W. Harrison Welch, PE
Stonewall Structural Engineering, PLLC
9203 Baileywick Rd. #200
Raleigh, NC 27615
(919)407-8663

Re: Review of Proposed Foundation Repairs — 130 Edna John Court, Dunn, NC 28334

At your request, Stonewall Structural Engineering (SSE) was consulted to review and provide recommendations for interior foundation repairs/replacements proposed by Tar Heel Basement Systems at the above referenced address. The purpose of the proposed foundation repair(s) is to address issues observed by Tar Heel Basement Systems while on-site March, 5 2025.

Picture 3 – Leaning and Failed Foundation Elements

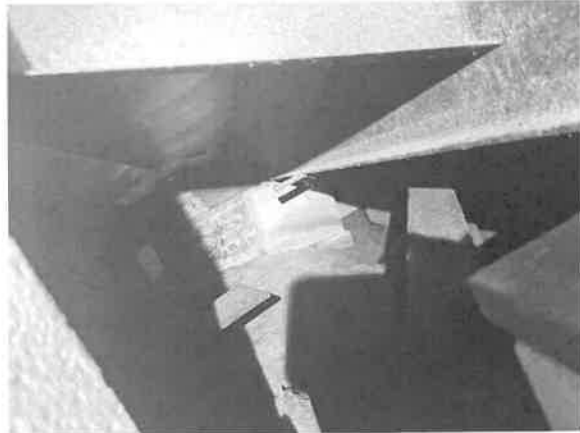
1. A total of seven (7) masonry piers were either significantly leaning, out of contact with the chassis beam, or had failed (see pictures 3-5).
 - a. Drainage concerns and evidence of soil erosion was noted in the crawlspace (see picture 6).

1. Replace each of the failed/leaning foundation piers with an IntelliJack support on well-compacted 24"x24"x18" gravel footings. Jacks should be located at the same location of the currently failed piers.
 - Fasten the IntelliJacks to the Chassis beam using Simpson "XQ1S1214" Self-Tapping screws.
2. Install an in-ground drain along the inside perimeter of the foundation walls with discharge through the low point of the crawlspace to the exterior of the home and discharge at least 3' from the perimeter of the structure onto soils adequately sloped away from the home.
